From: Sue Howell
Sent: 26 February 2025 13:39
To: Planning.Responses; Jessica Riches
Subject: Planning Consultation on: F/14/24/RES, F/15/24/RES, F/16/24/RES

Response to Planning Application

Application ref: F/14/24/RES, F/15/24/RES, F/16/24/RES

Location: Land at Ford Airfield Ford

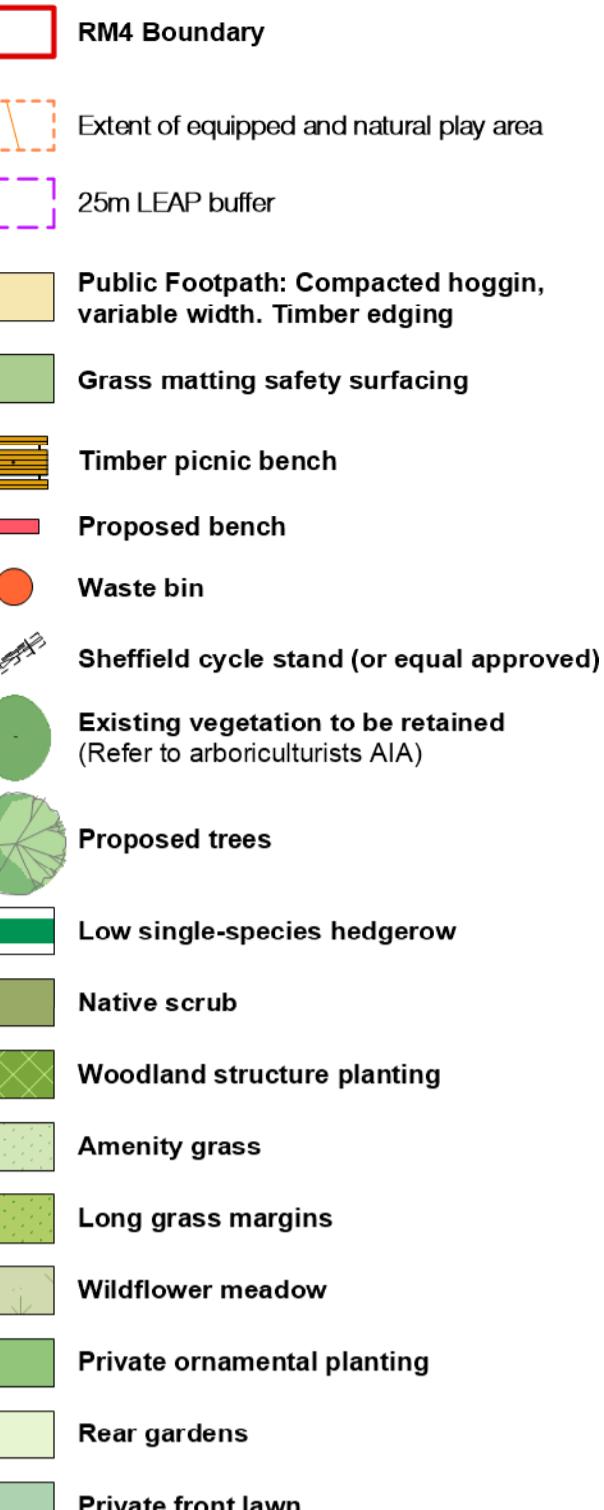
Play Areas were previously advised required amendments to maximise play space and reduce duplication of play items - Note on drawings RM4-XX-DR-L-P-031 and RM4-XX-DR-L-P-

032 explains the play spaces are shown indicatively, to be agreed in consultation with ADC and secured by condition. **Request** condition for play
